COMMUNITY SERVICES DEPARTMENT

Subject: Carriage Meadows South at Lorson Ranch Final Plat (PUDSP-16-002)

The Planning Division of the Community Services Department has reviewed the development application for Carriage Meadows South at Lorson Ranch Final Plat and has the following comments of behalf of El Paso County Parks. The original Carriage Meadows South at Lorson Ranch PUD Development Plan and Preliminary Plan was previously considered by the Park Advisory Board on August 10, 2016 and endorsed the following recommendation:

*THE MEADOWS AT LORSON RANCH
FILING NO. 4*
(NOT A PART OF THIS SUBDIVISION)

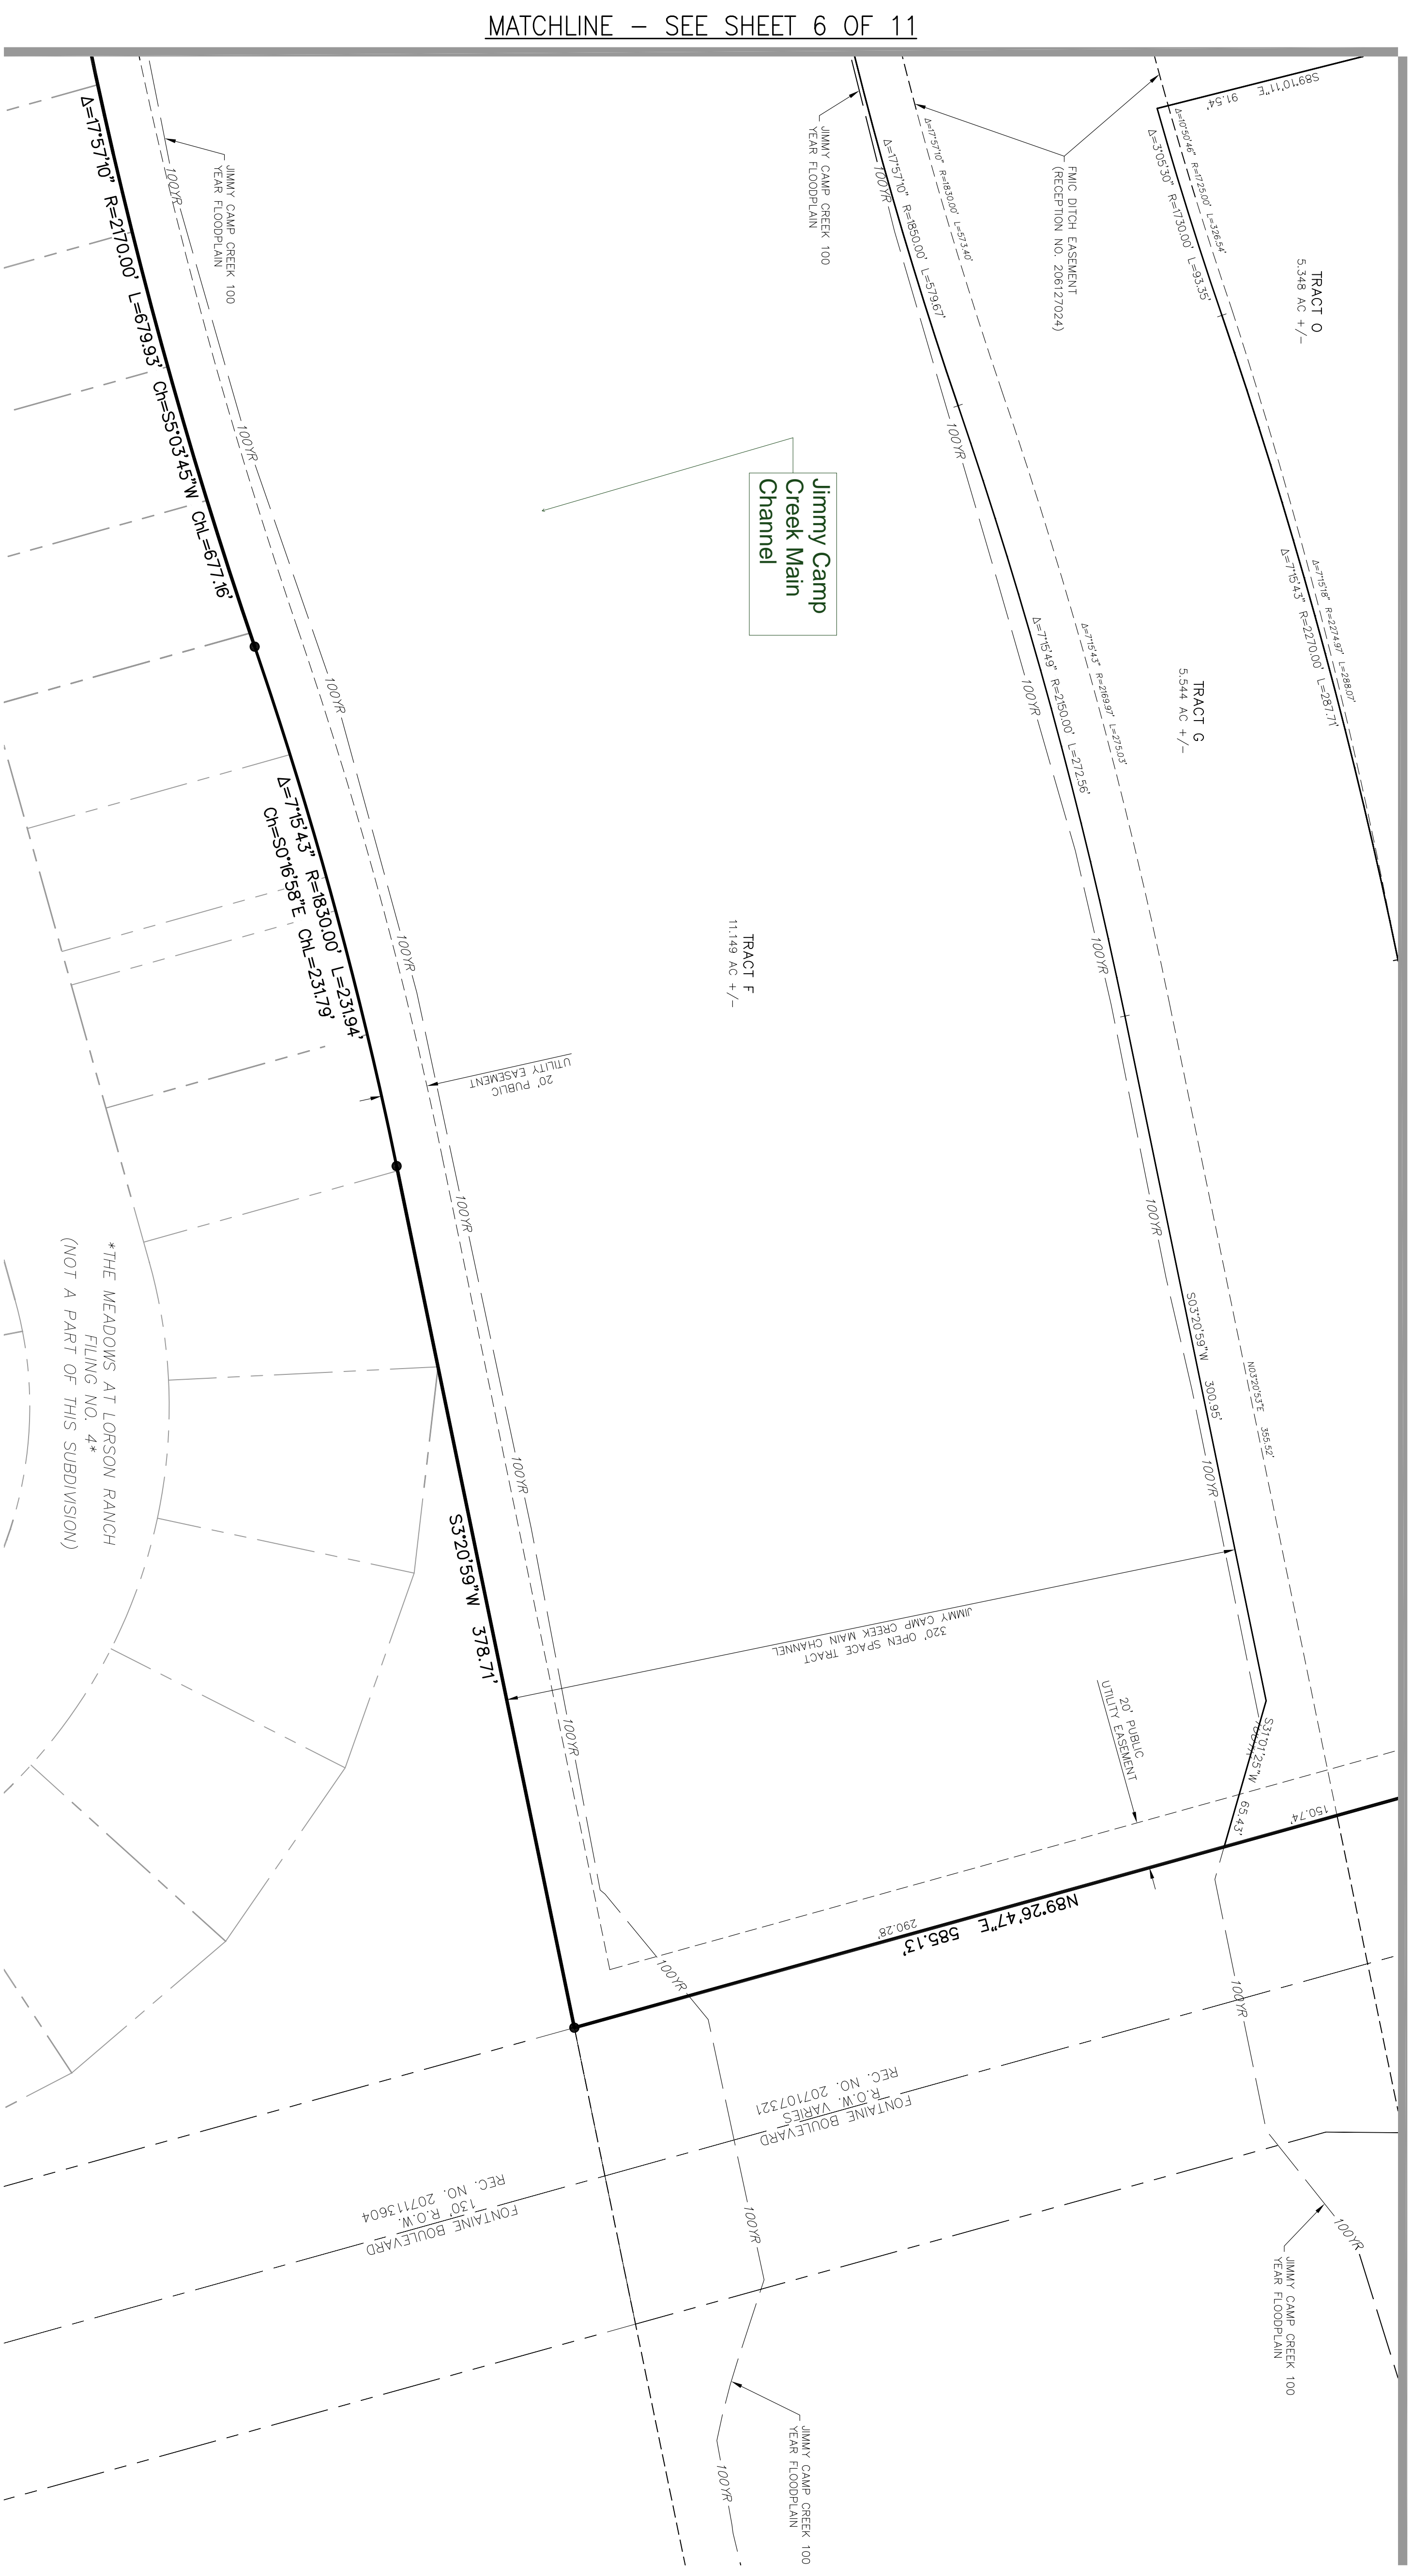
The El Paso County Parks Master Plan shows the Jimmy Camp Creek Primary Regional Trail running along the eastern edge of Jimmy Camp Creek within the project area. The previously approved PUD/Preliminary Plan drawings show the regional trail but it is not shown on the Final Plat drawings. Therefore, Park staff recommends

that Final Plat drawings show the regional trail along the eastern edge of Jimmy Camp Creek, and dedication of the 25-foot wide regional trail easement within Tract E and F to the County for regional trail purposes.

Recommend to the Planning Commission and Board of County Commissioners that approval of Carriage Meadows South at Lorson Ranch Final Plat include the following conditions: (1) A 25-foot wide public trail easement shall be provided and shown on the final plat for a Regional Trail along the eastern edge of Jimmy Camp Creek; (2) Require fees in lieu of land dedication for regional park purposes in the amount of \$95,645 and urban fees in the amount of \$60,395.
